Engineers Comments Regarding Surface Water Drainage

Application Reference:	BN/132/24/HH	Reviewer Reference:	ADC/SB
Planning Officer:	Hebe Smith	Date of Review:	03/12/2024
Site Name:	29 Cherry Tree Drive Eastergate PO20 3RR		
Application Description:	Construction of a single-storey side extension to the existing eastern elevation.		
Assessment Number:	1 of 1

① ROOF PLAN - AS PROPOSED
Scale: 1:50

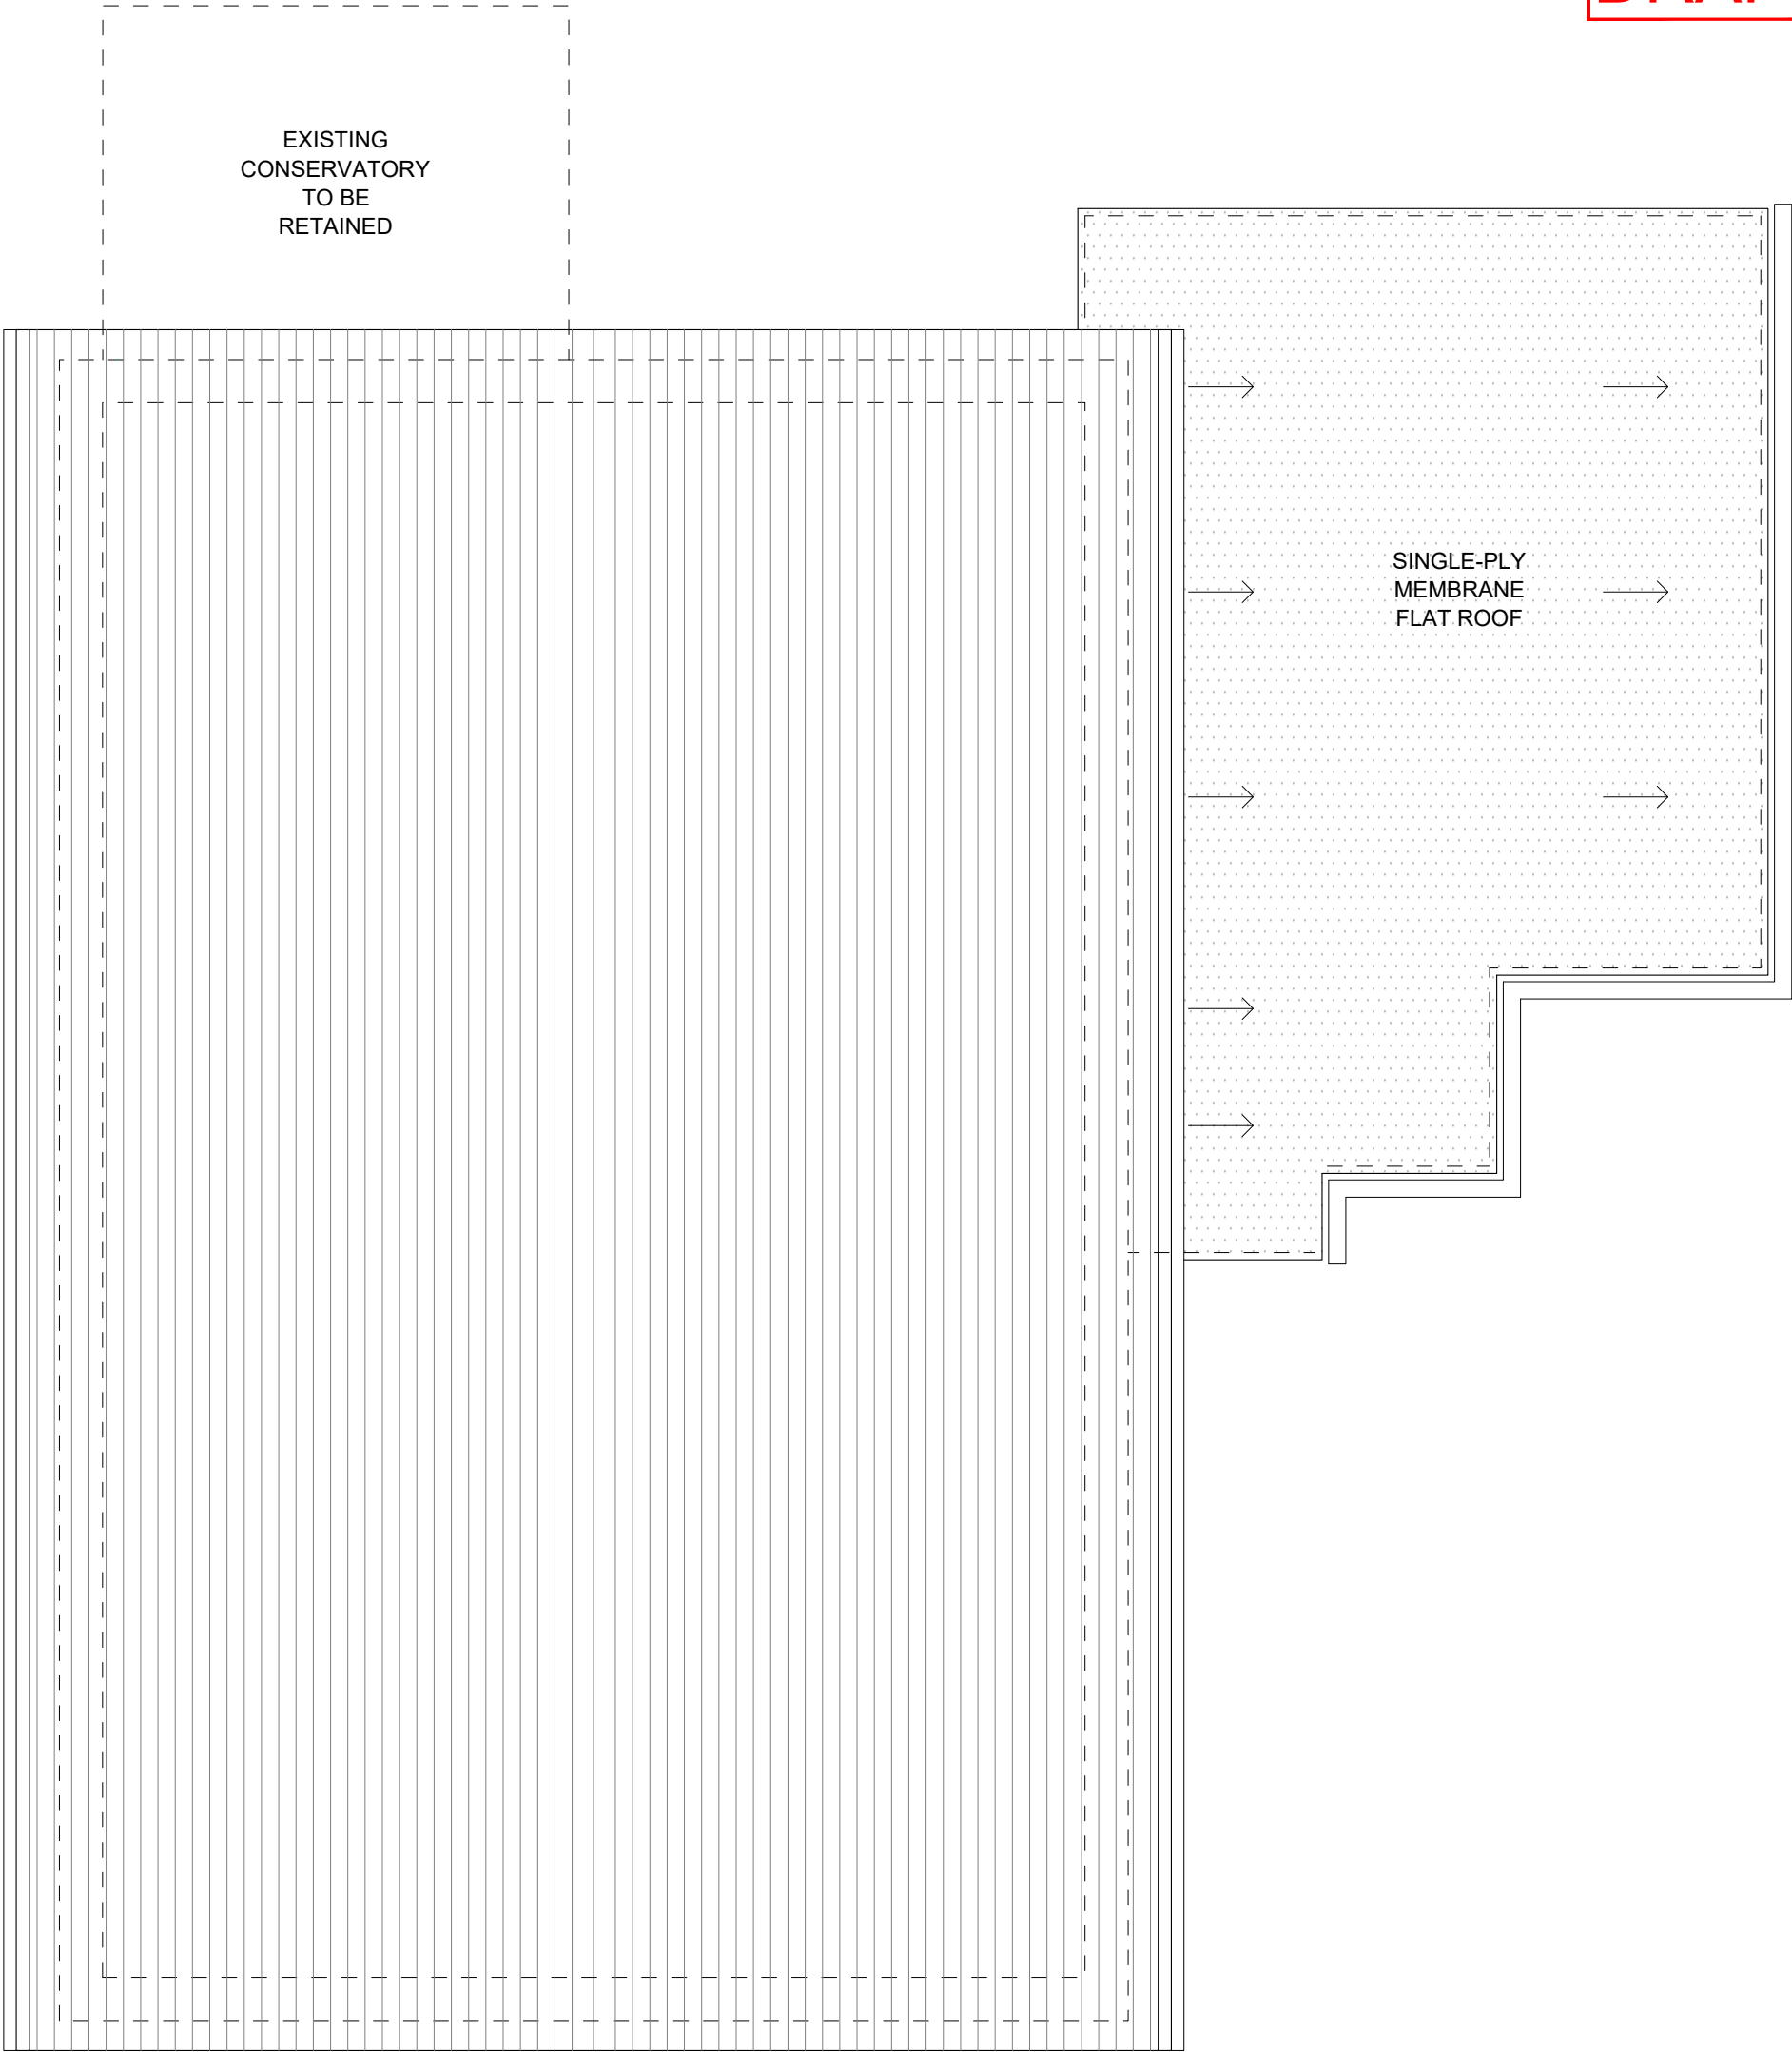
A Lidsey Drainage Impact Assessment has been submitted which indicates that surface water will be drained via a soakaway. Nothing has been submitted to evidence that draining by infiltration is viable or that there is enough space on the site to accommodate a soakaway.

Further information is required to demonstrate how the existing site drains surface water. If infiltration is not viable and connection to alternative system cannot be achieved, it may not be able to drain surface water sustainably.

1. Provide evidence of a sustainable surface water disposal location. Including but not limited to:

- Winter groundwater monitoring and winter infiltration testing,

Figure 1 Extract from Flood Maps for Planning [https://flood-map-for-planning.service.gov.uk]

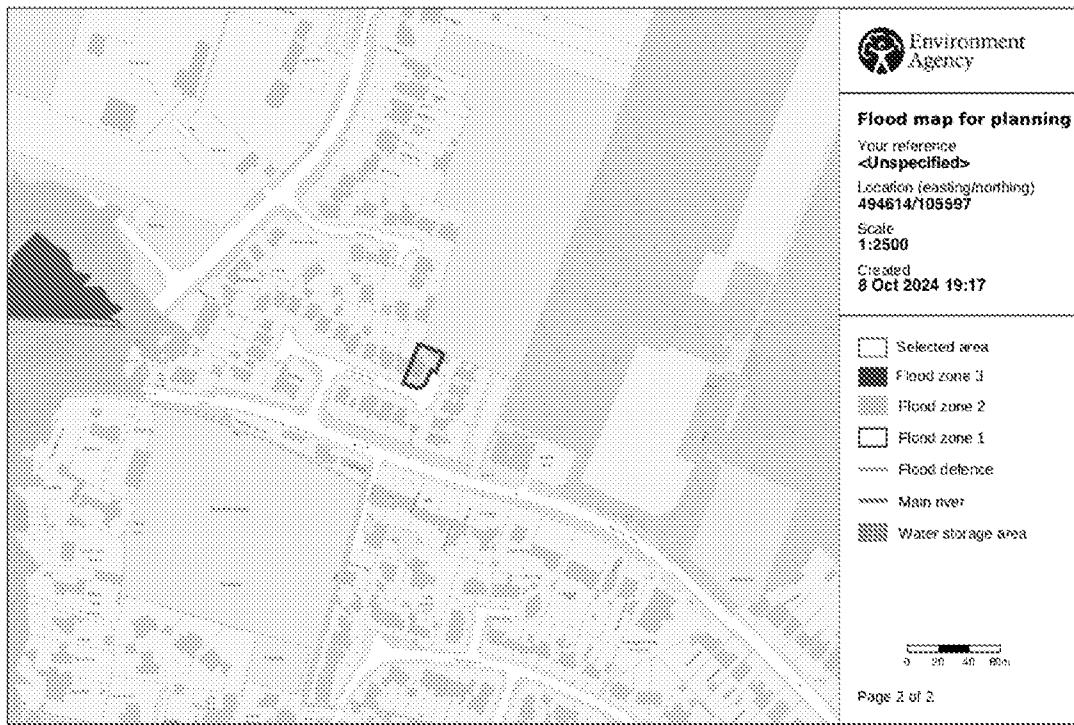
The site is fronted by an area at risk of surface water flooding, on the 0.1% Annual Exceedance Event (with no allowance for climate change) on Fontwell Avenue. It is also in the Lidsey Wastewater Treatment Catchment [WWTC] Area which is the subject of a surface water management plan.
